3.4 CHILD CARE FITOUT

3.5 BUILDING HEIGHT

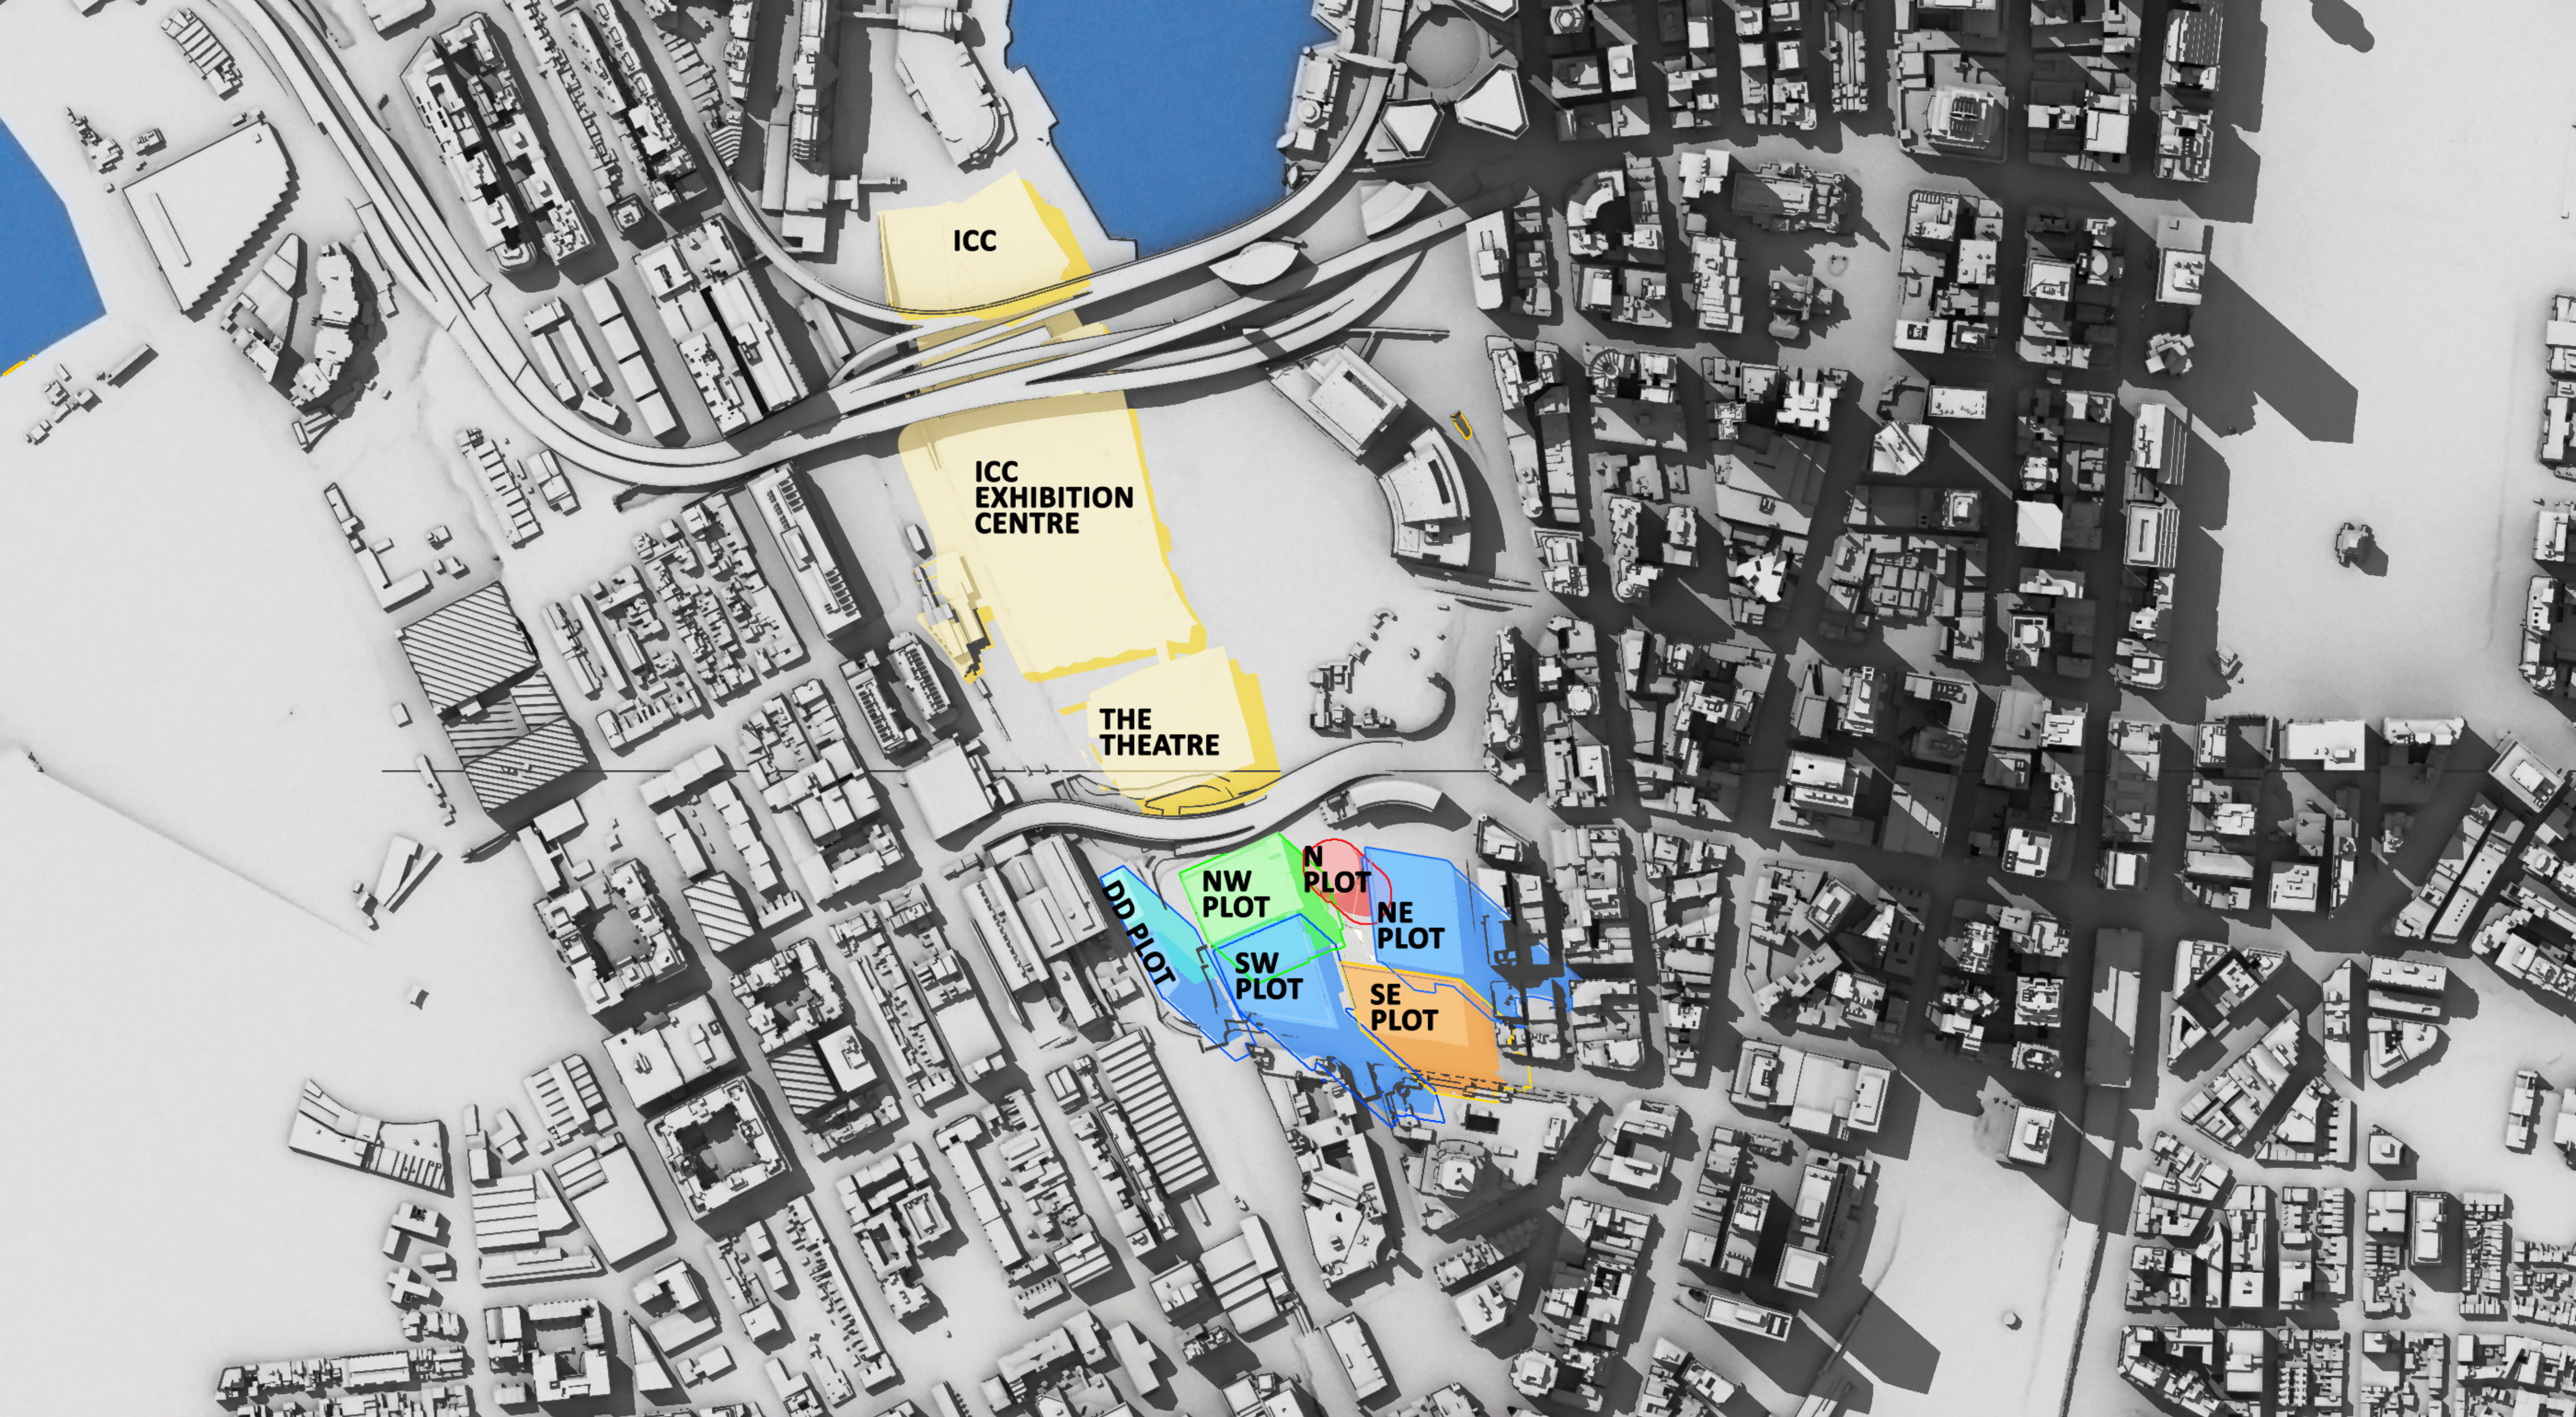
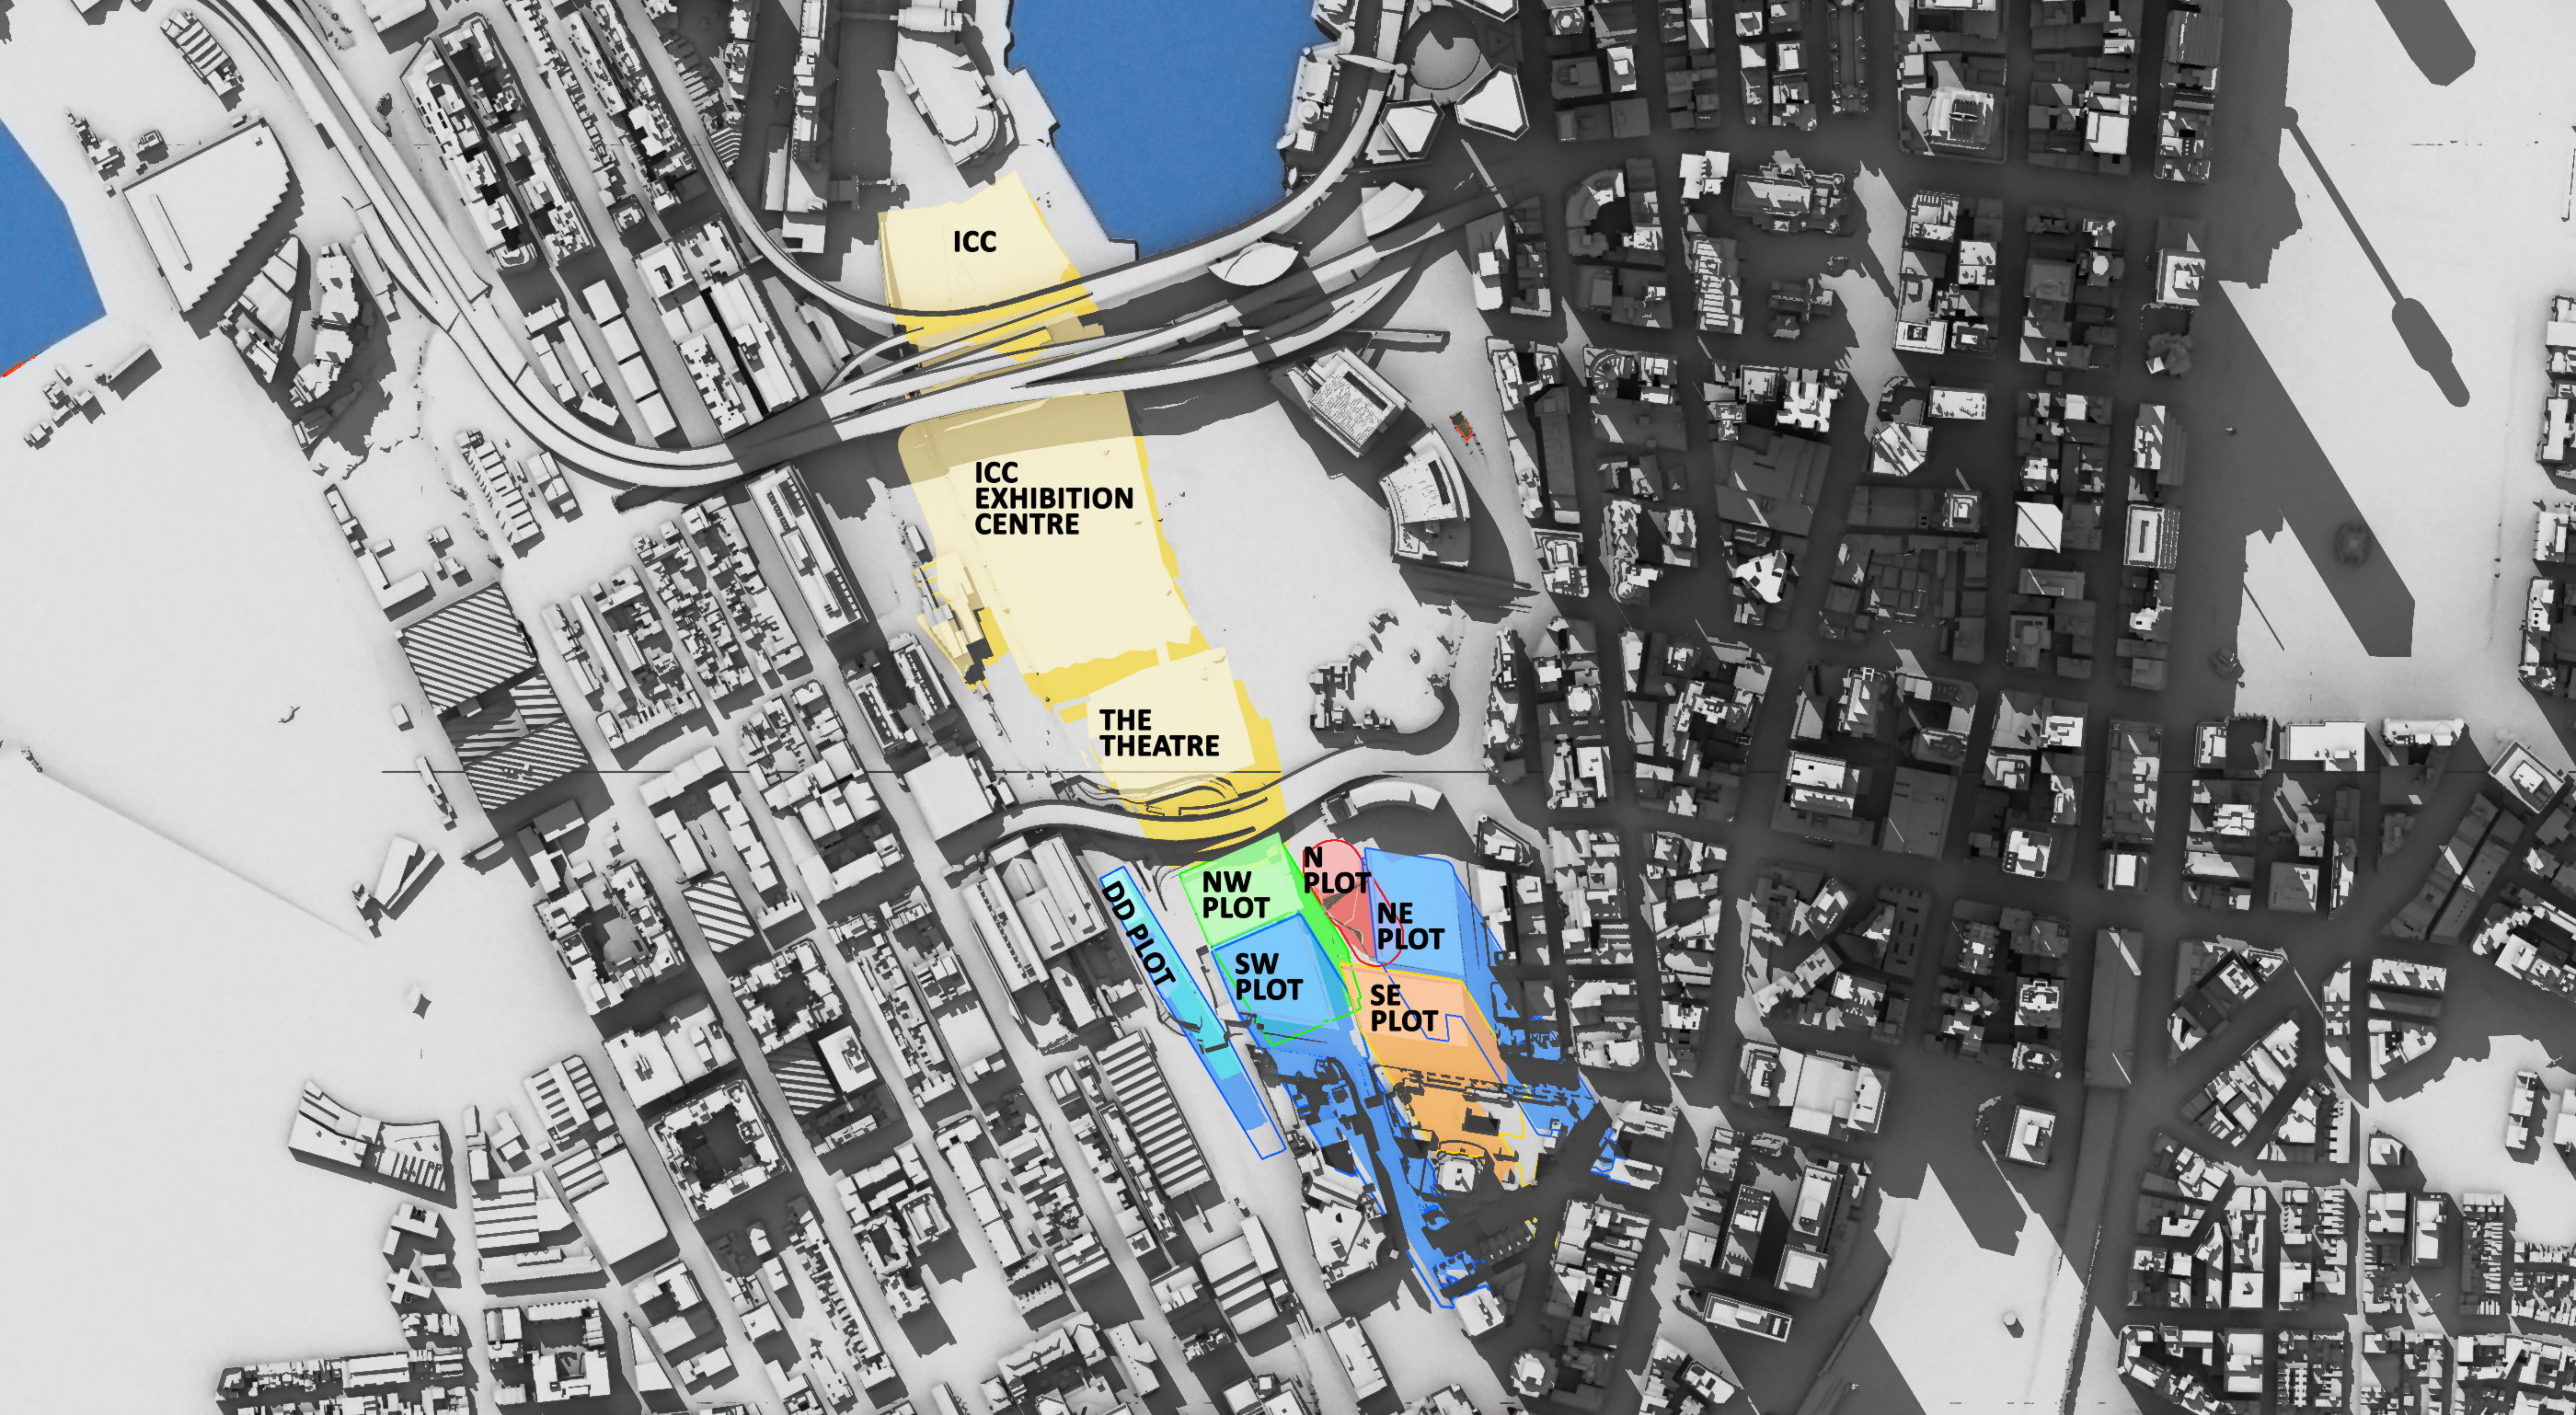
The Authority notes that the height of the proposed building (Darling Exchange) on the North Plot has increased by 5 metres. Any increase in building height should not create additional overshadowing across Haymarket Square during mid-winter. Further modelling is considered necessary in order to ensure solar access across Haymarket Square is maximised, especially the critical 12 midday to 2.00pm lunch time period during mid-winter and to confirm that the built form of the Darling Exchange does not dominate the public square.

The impact from the 5m increase in height has been assessed in great detail as part of the S96 modification to the Concept Plan which has now been approved. The building is entirely within this parameter plan and consistent with the overall parameter plan height control.

The building has been positioned to minimise the shadowing throughout the year. Refer to Appendix B - Shadow Analysis for further information.
